**From:** [REDACTED]  
**To:** [Planning](#)  
**Subject:** FW: Land off Shire Lane 3/2026/0159  
**Date:** 26 March 2026 11:16:00

The applicant has sent a visibility splay drawing for the site access.

SITE LOCATION PLAN  
AREA 2 HA  
SCALE: 1:1250 on A4  
CENTRE COORDINATES: 367832 437990

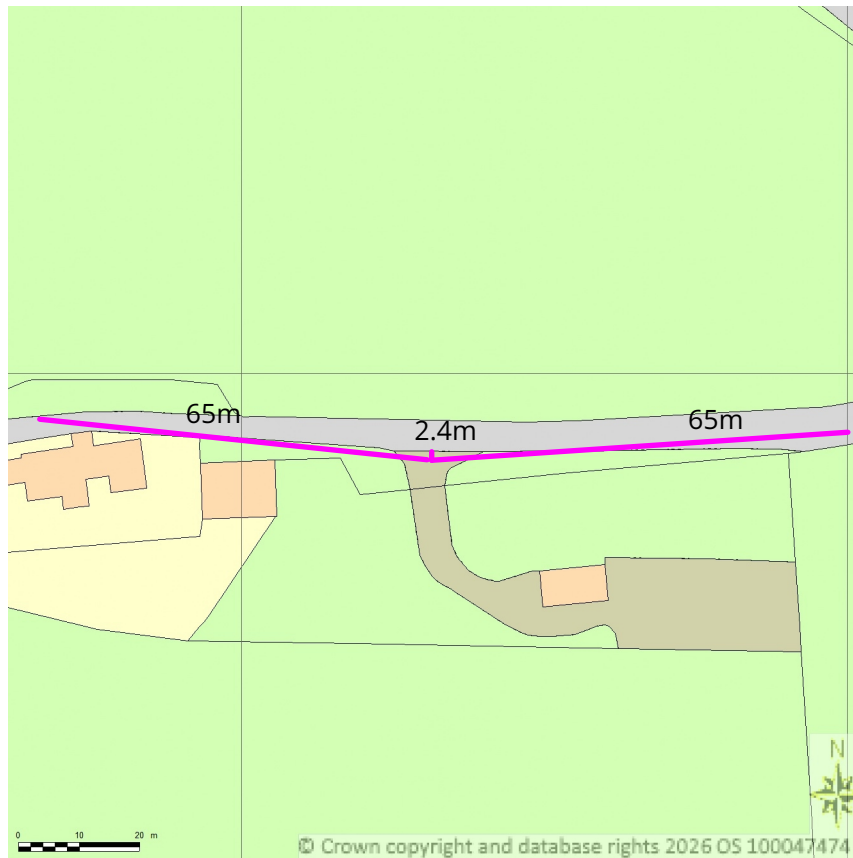
My comments original comments remain the same.

The visibility at the site access itself is not the issue, it's the splays on the wider network connecting to Longridge Road which are the concern.
